WEST SUSSEX COUNTY COUNCIL CONSULTATION

TO:	Arun District Council FAO: Mr S Davis
FROM:	Emma Avis, Planner, Highways, WSCC
DATE:	20 th December 2018
LOCATION:	Nyton Stables, Nyton Road, Aldingbourne, Chichester, PO20 3TX
SUBJECT:	AL/107/18/PL Application for continued use for 3 No. approved permanent showpersons plots (temporary permission granted under AL/119/10/ & permanent permission granted under AL/10/14/PL), planning permission for a further 8 No. plots consistig of 4 No. existing & 4 No. new plots (to a maximum of 11 plots) with associated hard & soft landscaping, boundary treatment, lighting & associated works.
DATE OF SITE VISIT:	
RECOMMENDATION:	☐ Advice ☐ Objection ☐ Modification ☐ No Objection ☒ More Information ☐ Refusal
S106 CONTRIBUTION TOTAL:	£N/A See below for breakdown.

Existing and Proposed Plots

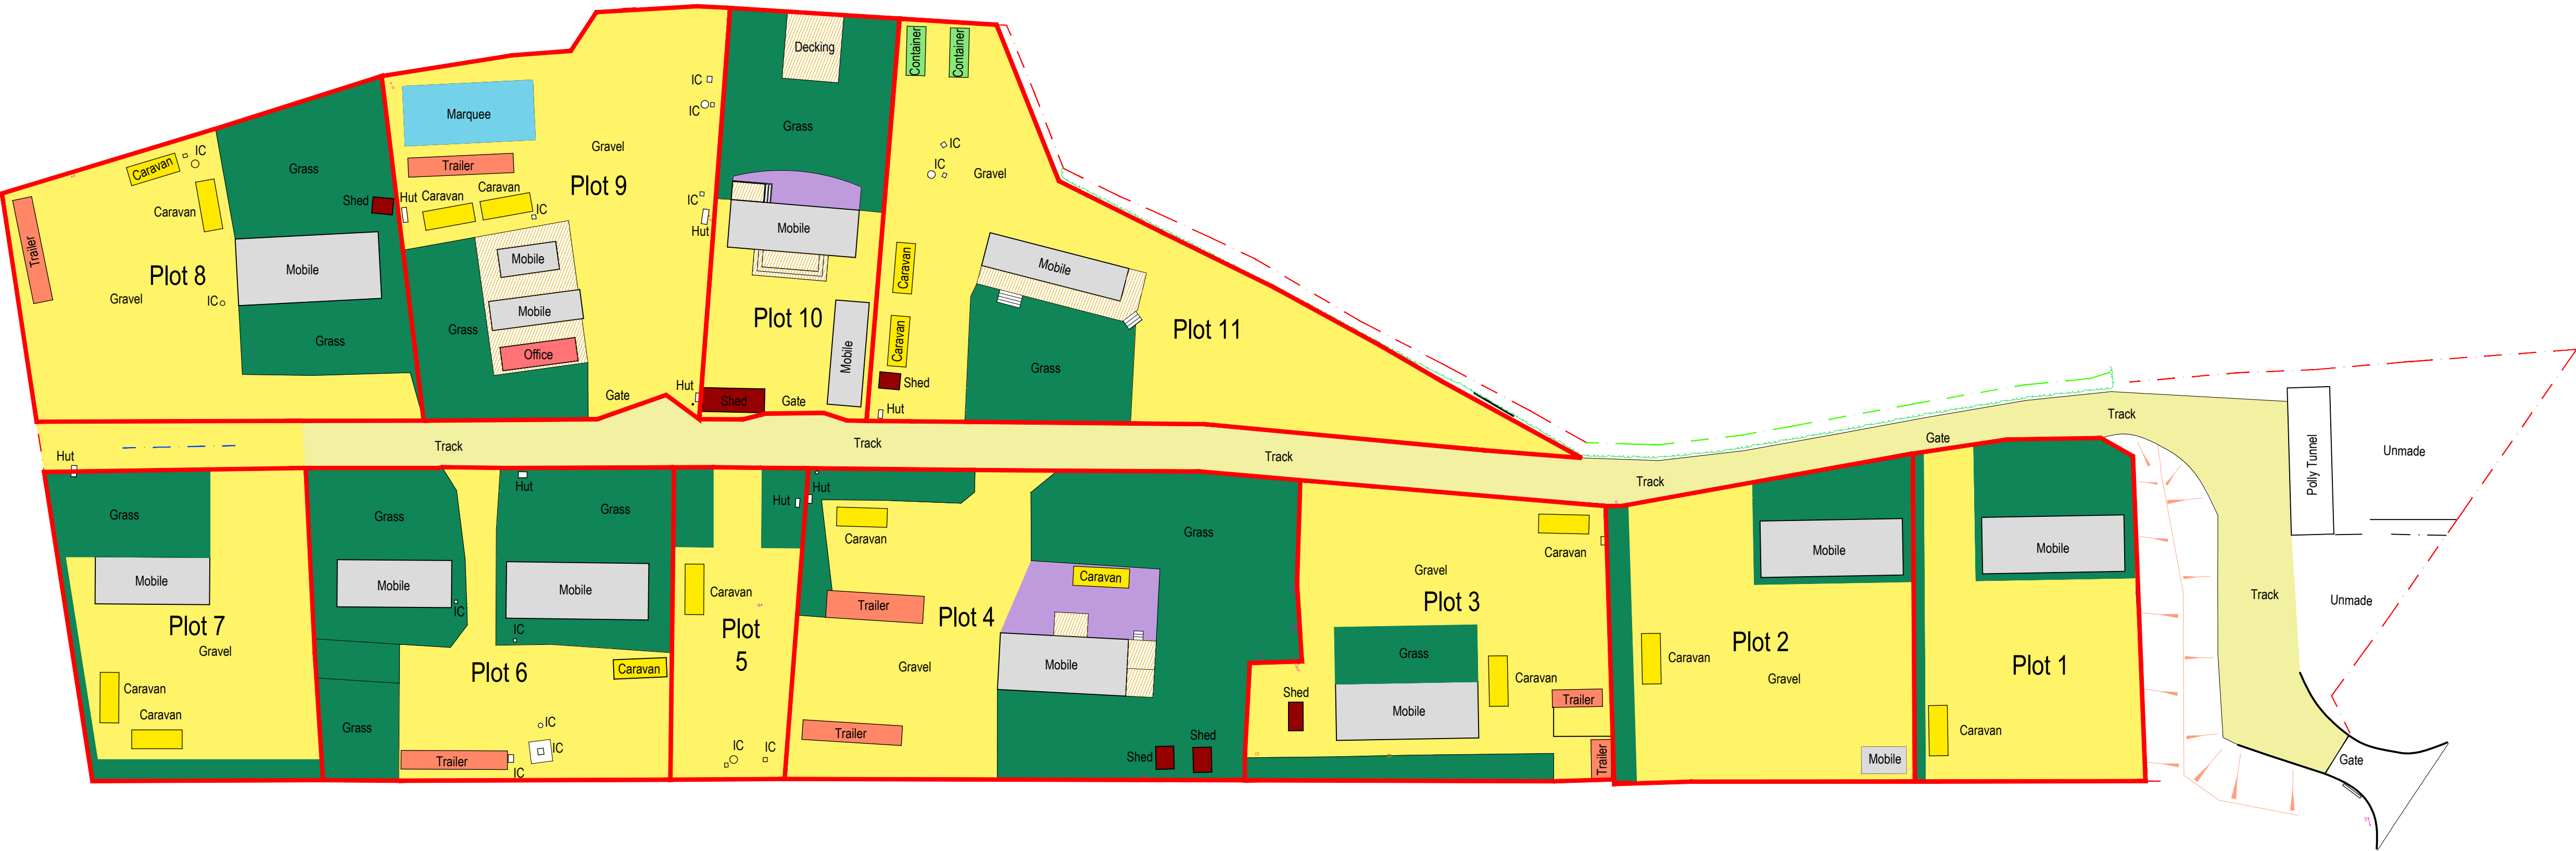
- Clarification on the increase in vehicle movements (existing/proposed)
- Tracking plans demonstrating that the existing access is capable of accommodating the largest vehicle that is expected to enter and exit the site. It is noted that the access is existing but it only has permission to serve 3 plots and this permission was granted some time ago. Given the increase in use that is proposed the access needs to be assessed for intensification of use.
